Online Comment

Application H17-0652-15
Location Off Sunnydale Close Surfleet Spalding PE11 4BS
Proposal Residential development for 26 No. dwellings including roads, footpaths and open spaces

Name Emily Spicer
Address Environmental Services

Title
Proposed Site Plan

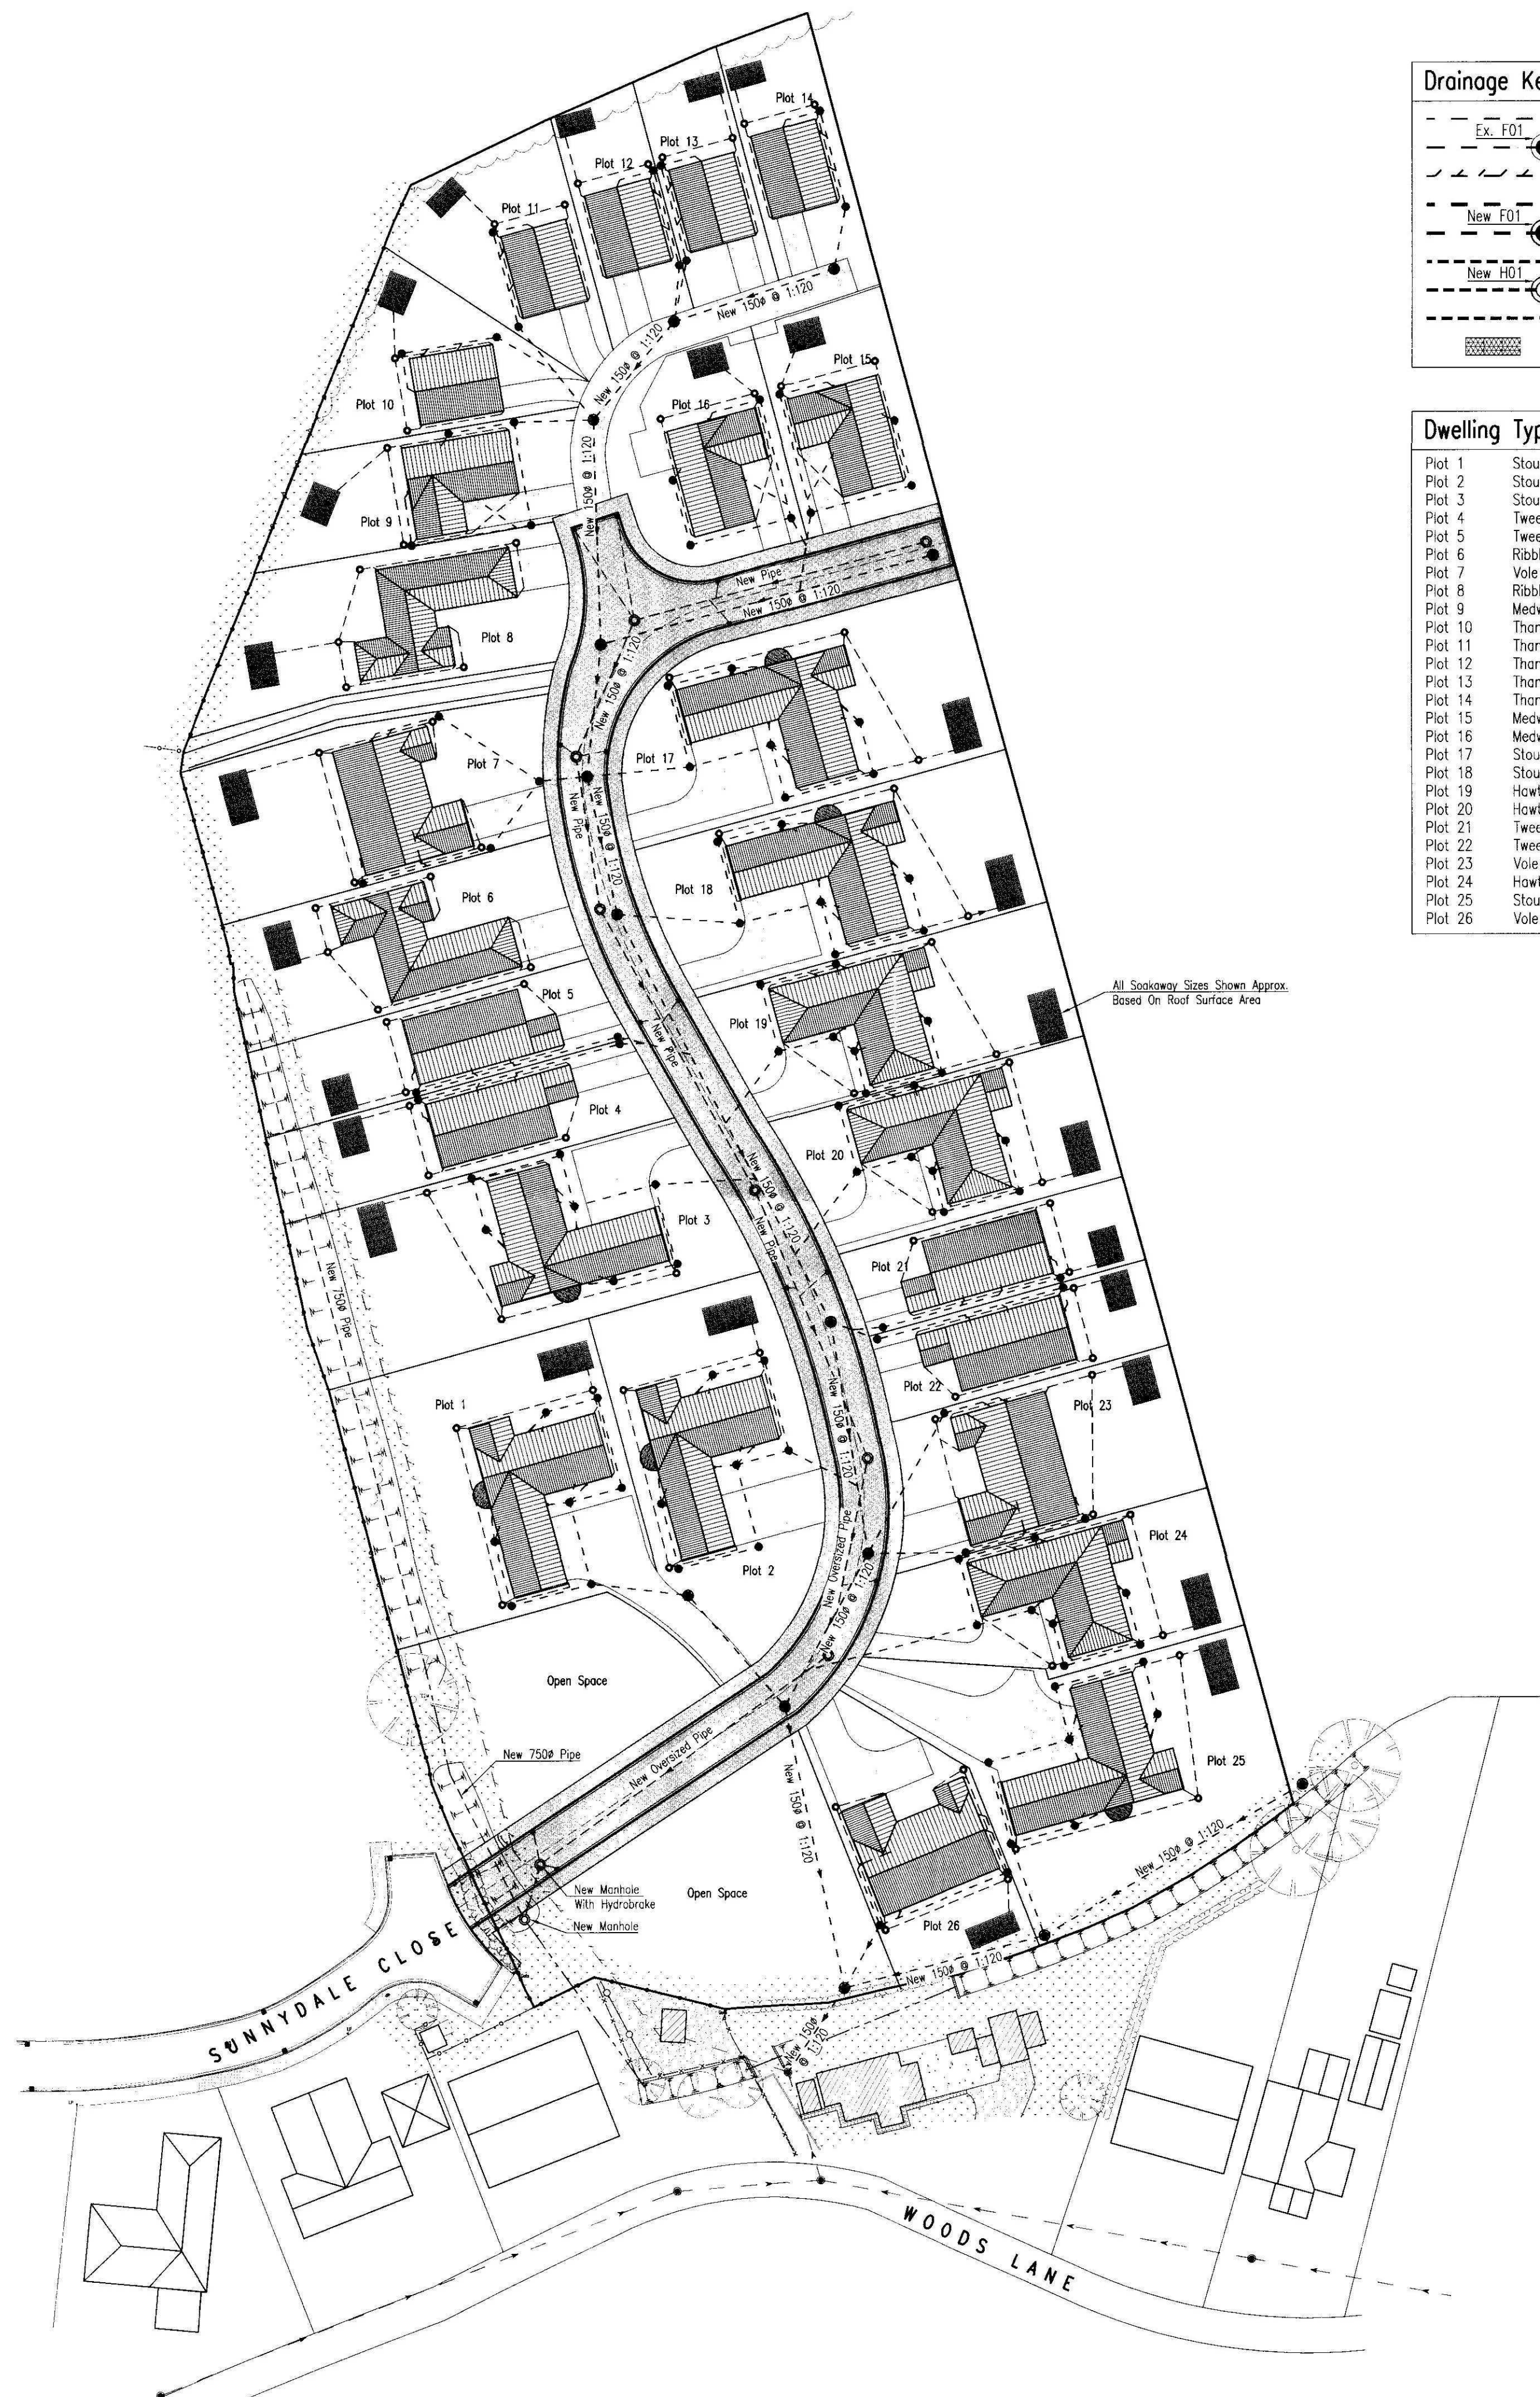
South Holland District Council operates a weekly collection for both materials for recycling and refuse. I note that part of this proposed development will be serviced by a private road and therefore residents here will need to present their black and green sacks at the point the public road meets the private road. As Surfleets refuse and recycling day both fall on a Monday please may I be advised of the positioning of these sacks in order to minimise any disruption to households at the edge of the private drive. Thanks you
